Sea Link Energy Cable

Appendix A5 to the Natural England Deadline 5 Submission

Natural England's Additional Comments on the Suffolk Onshore

11th March 2026

Document Title: SUFFOLK ESTIMATED FUTURE EROSION

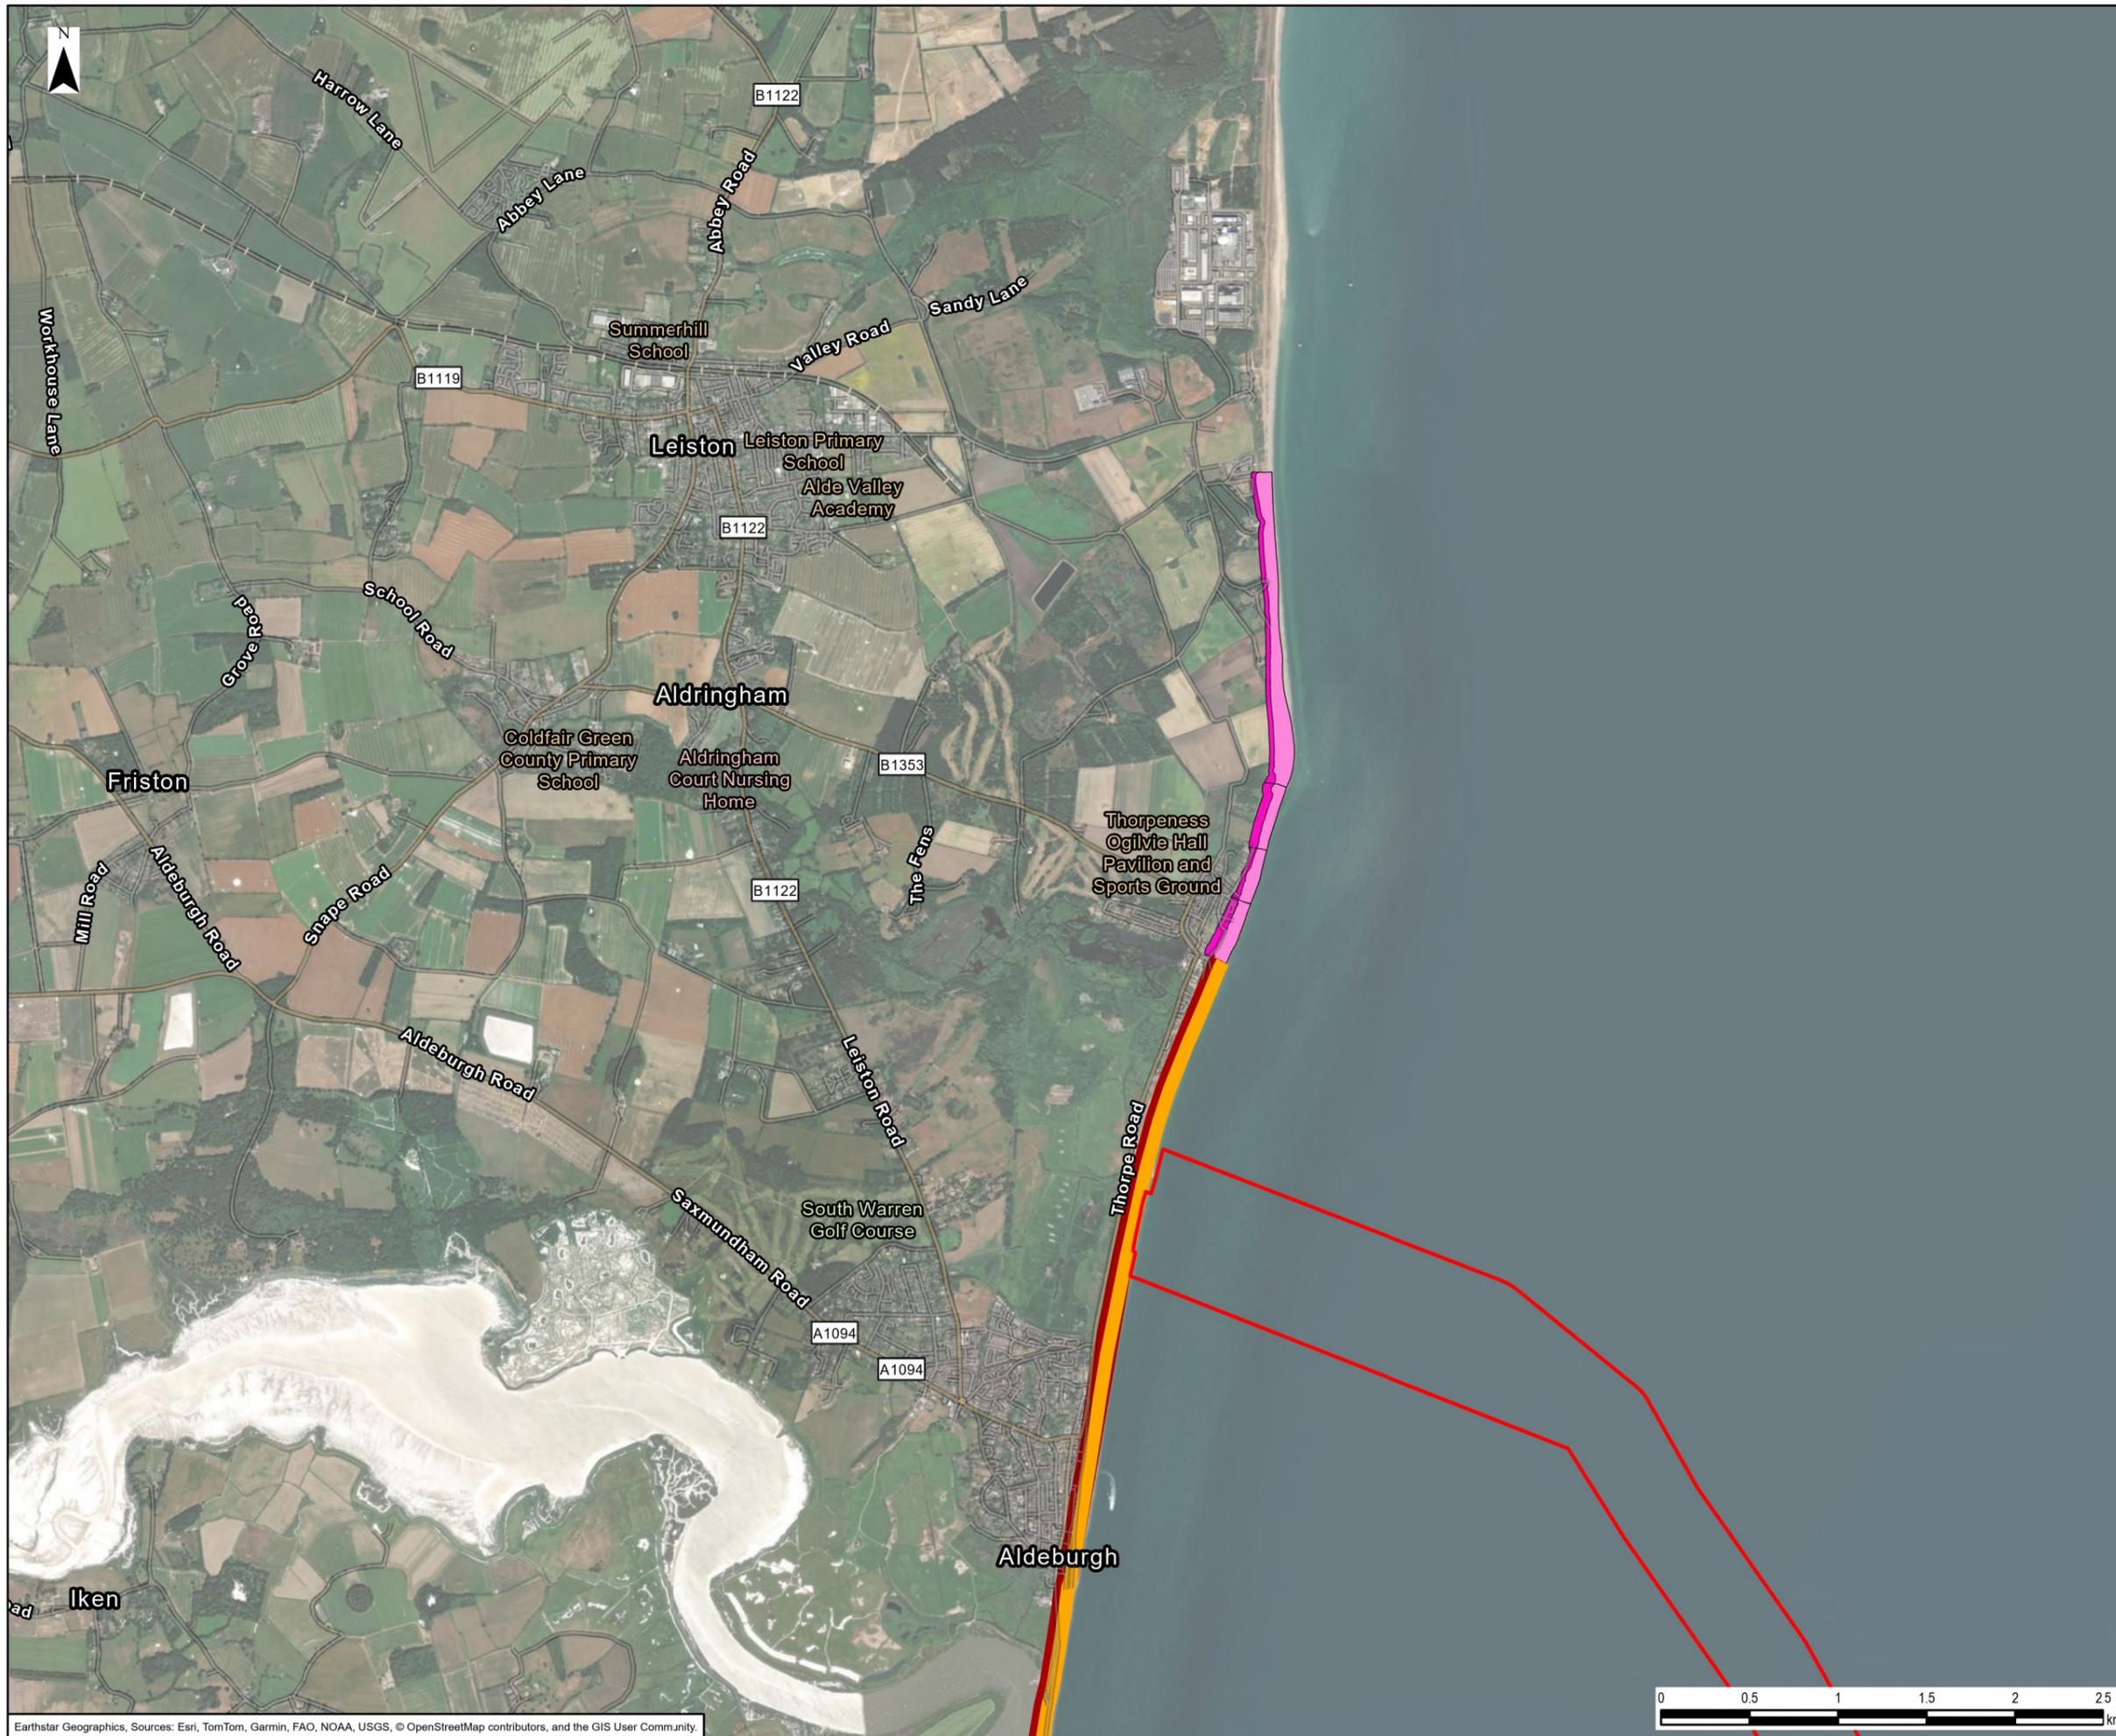
Document reviewed: [REP3-021] 6.2.4.1 Version D, Part 4 Marine Chapter 1 Physical Environment			
NE Ref	Section	Key Concern and/or Update	Natural England’s Advice to Resolve Issue
A5.9	1.7.6	<p>We note the changes made to Document 6.2.4.1 version D, Part 4 Marine Chapter 1 Physical Environment.</p> <p>Paragraph 1.7.6 states that the landfall site is within policy unit ALB14.1, and that the policy for Epoch 1 and 2 is for No Active Intervention, and for Epoch 3 Managed Realignment (MR). However, the landfall is actually within policy unit ALB14.2, which has a policy for MR within all three Epochs. Additionally, the policy for ALB14.1 was changed in 2015 and is also MR for all three Epochs.</p> <p>This information can be found on the gov.uk website: https://environment.data.gov.uk/shoreline-planning/unit/SMP7/ALB14.2</p> <p>However, we consider that this error does not alter the conclusions of the assessment. The offshore landfall transition bay will be more than 800m from the current coastline and the estimated erosion rate quoted in the report, based on the erosional frontages adjacent to the proposed HDD landfall point, is 77m by 2055 and 118m</p>	n/a

by 2105. As long as the cable is at a depth that means it will not be exposed by beach lowering as the cliff line rolls back there should be no change to the assessment findings.	
A5.10	1.8.3	Paragraph 1.8.3 states an embedded mitigation measure for Coraline Crag is to not pre-cut trenches but use cable protection (rock bags and mattresses). However, in line with our comments in Appendix A3 to Natural England's Deadline 3 Submission comments on Suffolk Onshore Ecology, there is no assessment of the potential impacts of cable protection on the area particularly where the bedform is mobile in nature. In addition, as also raised in our Deadline 3 Appendix A3, the HDD exit pits are proposed to come up through an area of Coralline Crag and no assessment of potential impacts to this geological feature is provided.	We advise these potential impacts should be assessed.
